Your Reference: MP10\_0168  
Our Reference: SYD10/00893  
Contact: Stella Qu  
Telephone: 8849 2520

**EXHIBITION OF ENVIRONMENTAL ASSESSMENT FOR MIXED COMMERCIAL  
AND RETAIL DEVELOPMENT (STAGE 1) AT 2 AUSTRALIA AVENUE, SYDNEY  
OLYMPIC PARK**

Chris Goudanas  
**Chairman, Sydney Regional Development Advisory Committee**  
19 December 2011

drawing title
Ground Floor Swept Path:Service Area Exit

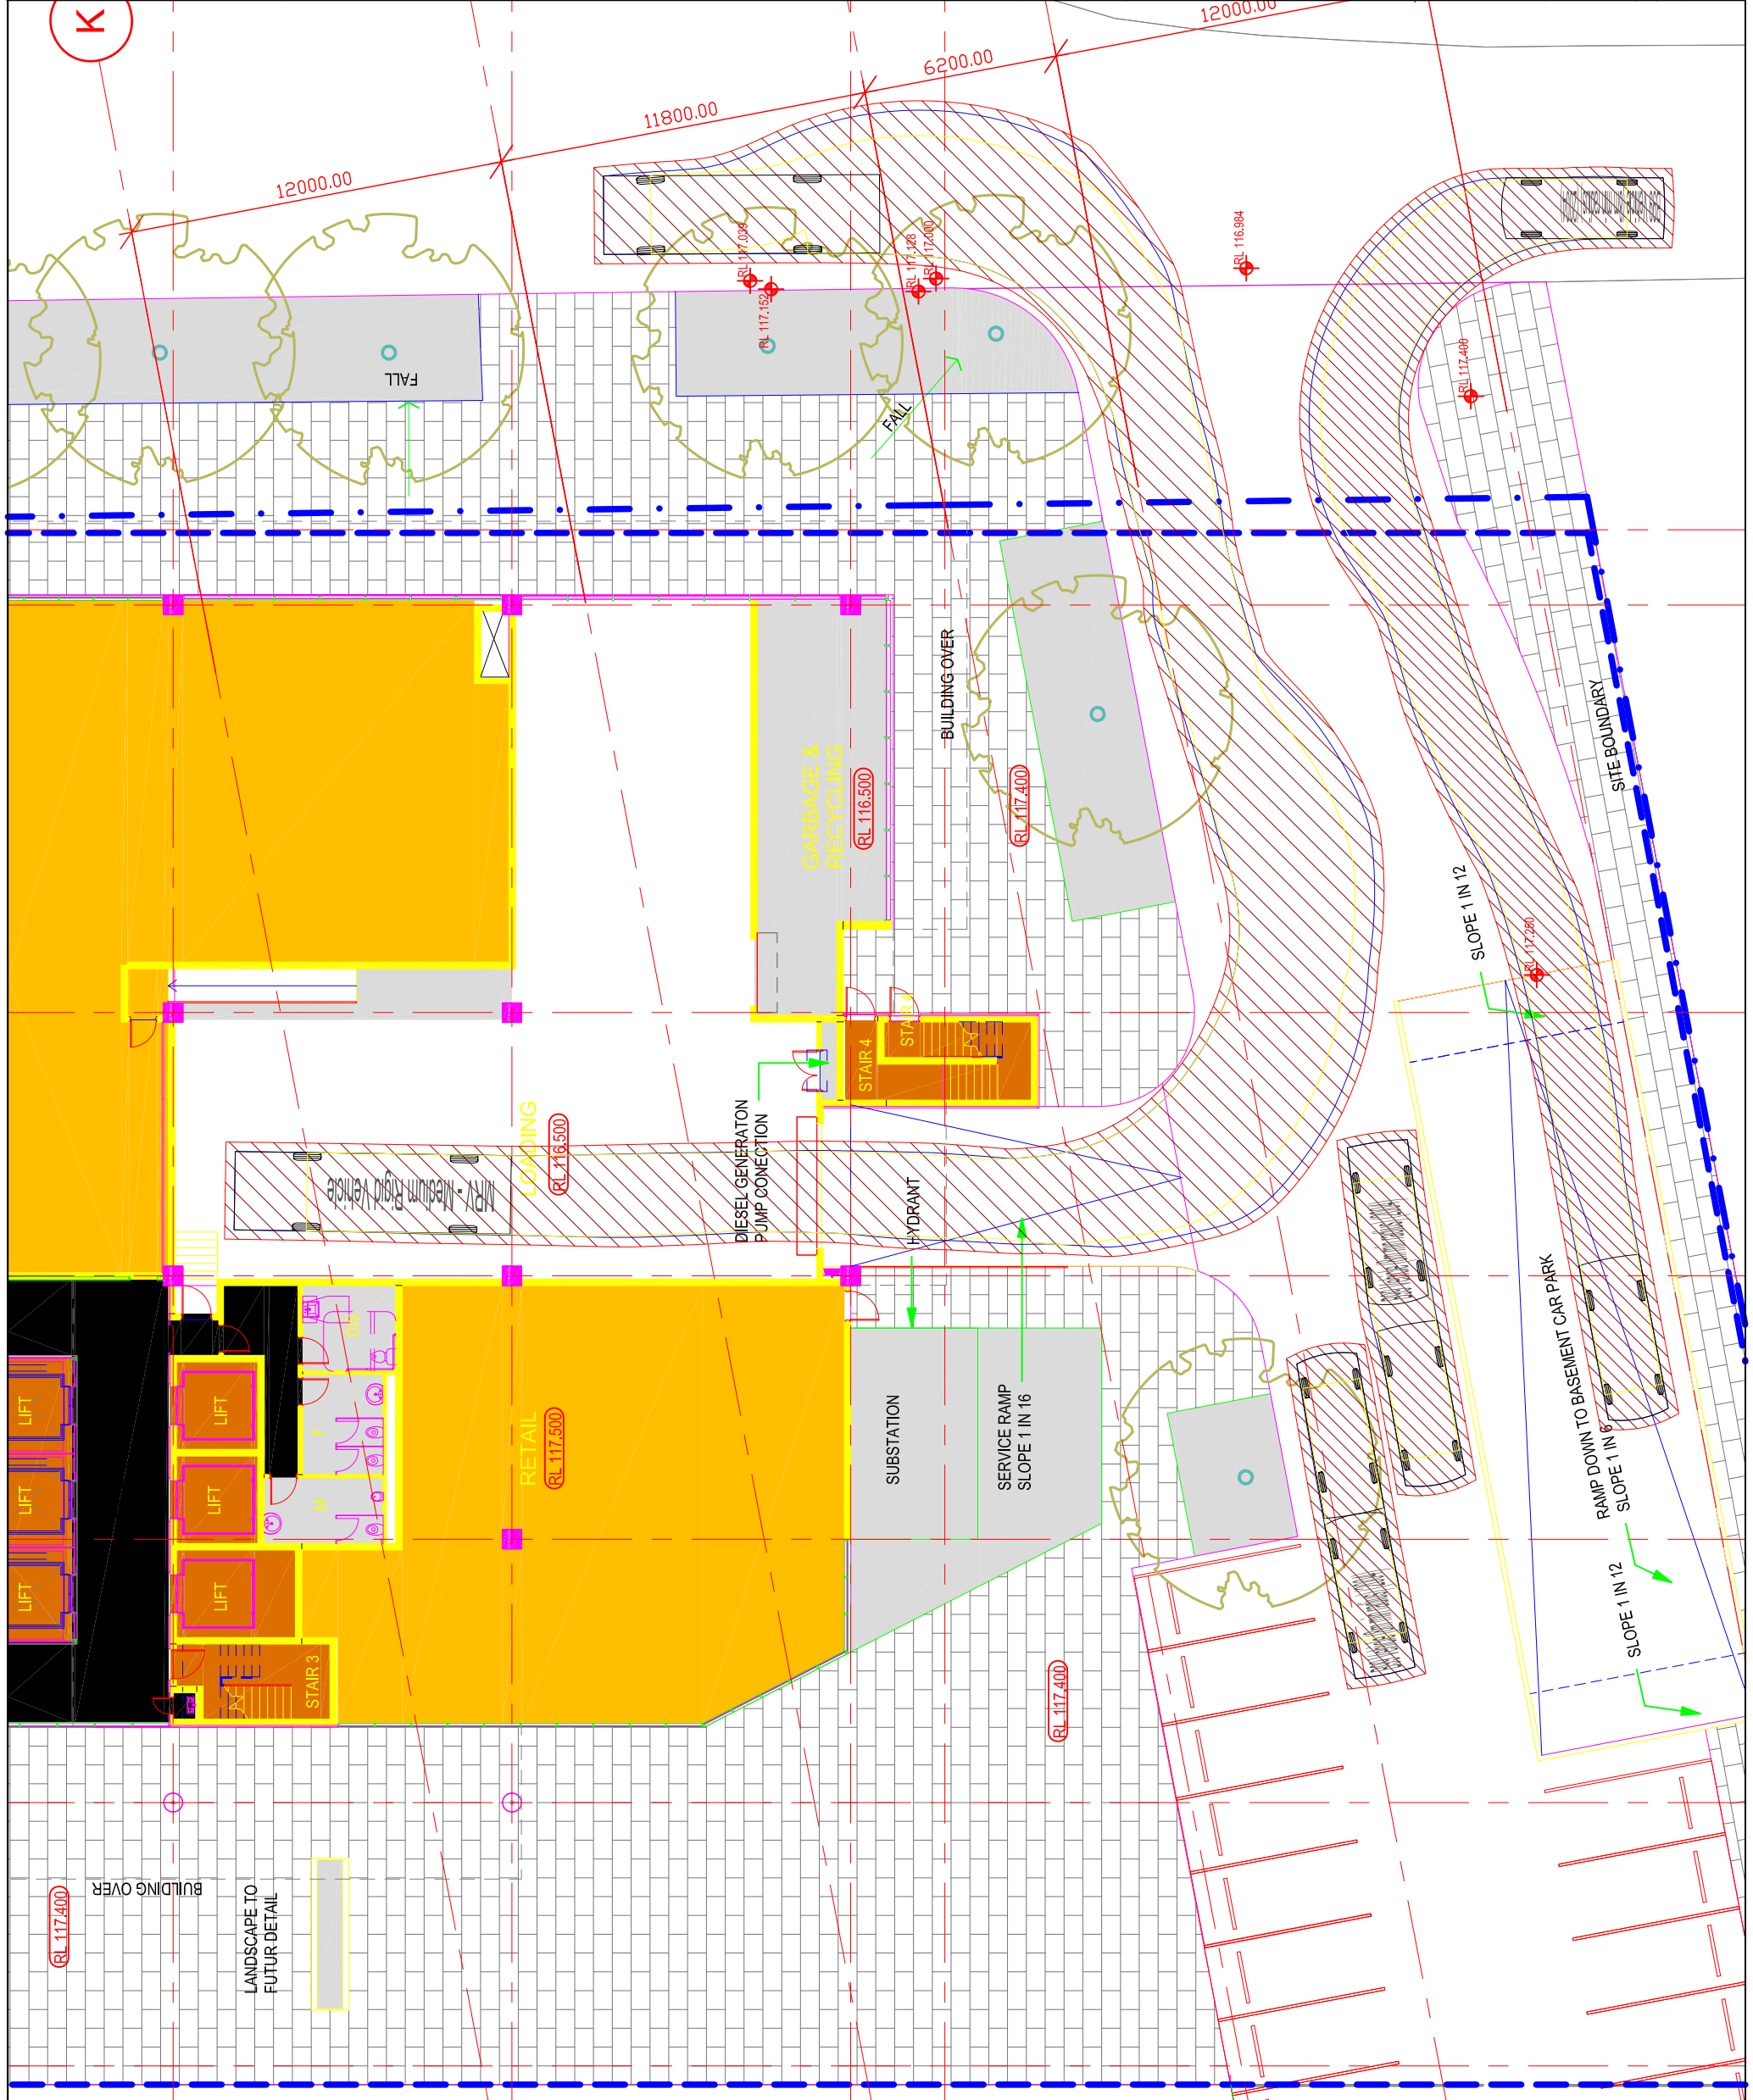
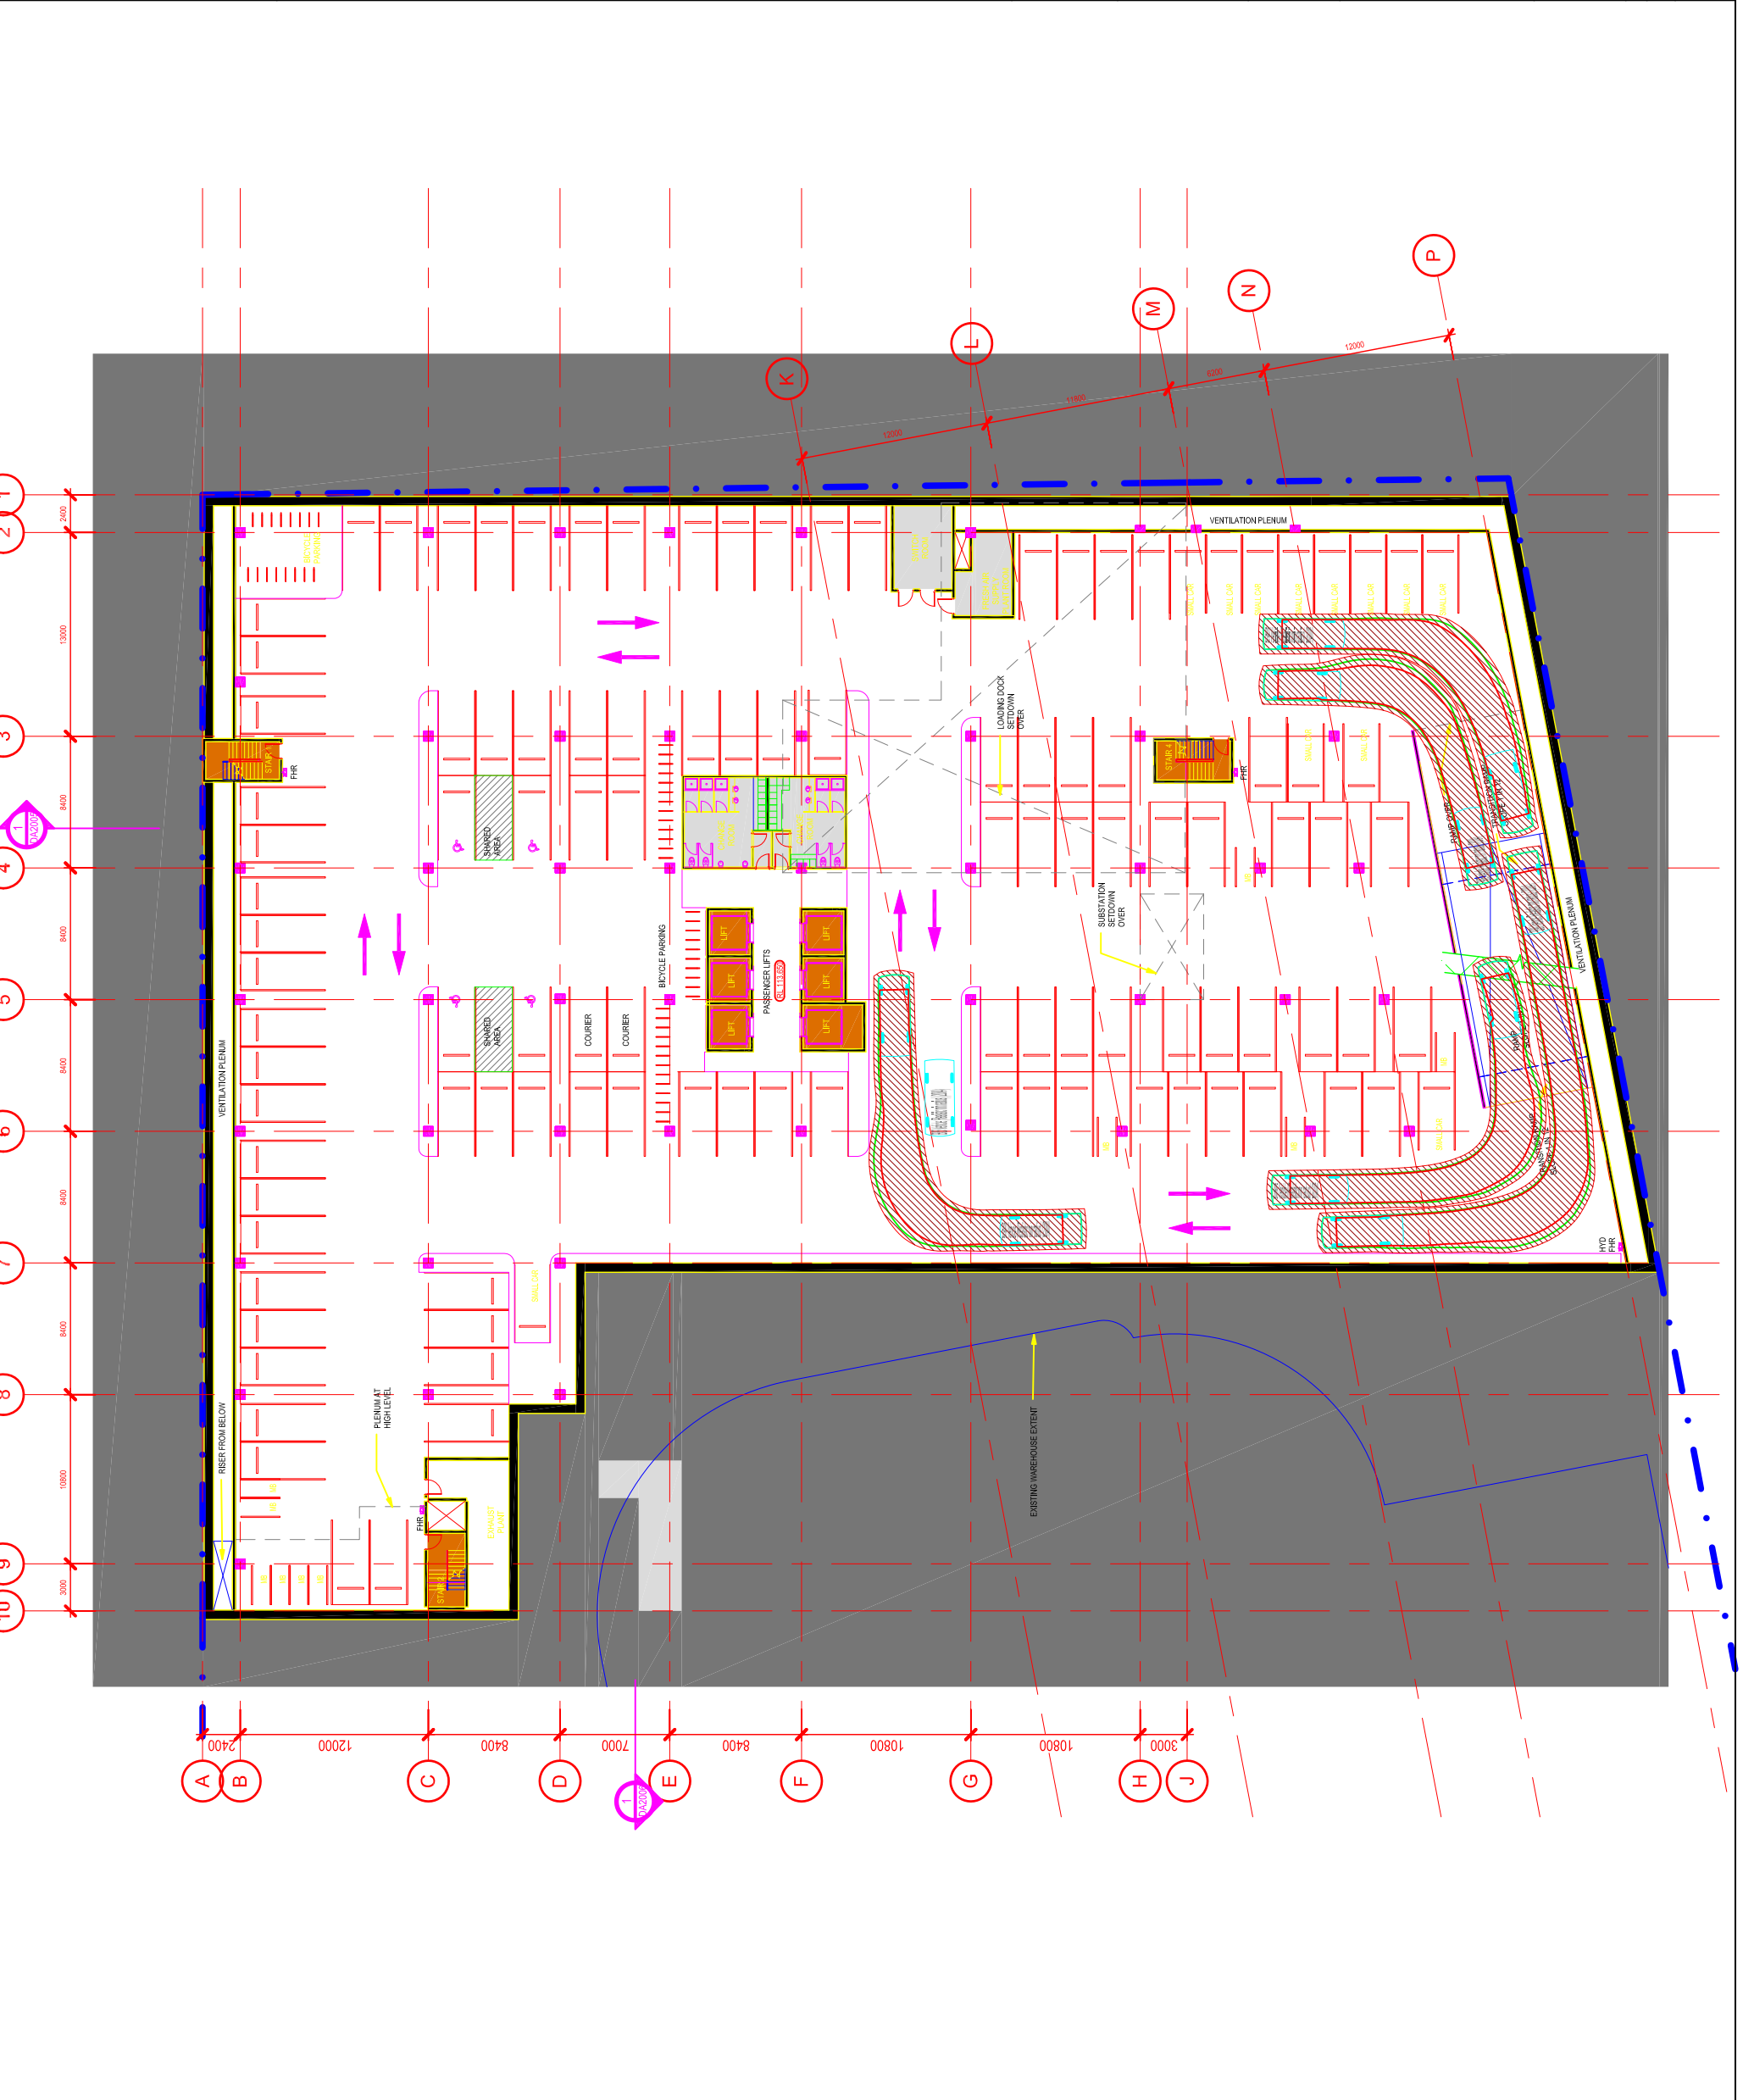
2. The swept path of the longest vehicle entering and exiting the subject site, as well as manoeuvrability through the site, shall be in accordance with AUSTROADS. It is noted that the nominated longest vehicle permitted to enter the site is 8.8 metre medium rigid vehicle (MRV). The DP&I shall be satisfied that the proposed commercial and retail land use will not be serviced by vehicles larger than 8.8 metres in length.
3. The number of car parking spaces shall be provided to the satisfaction of the Department of Planning & Infrastructure (DP&I) and Transport for NSW.
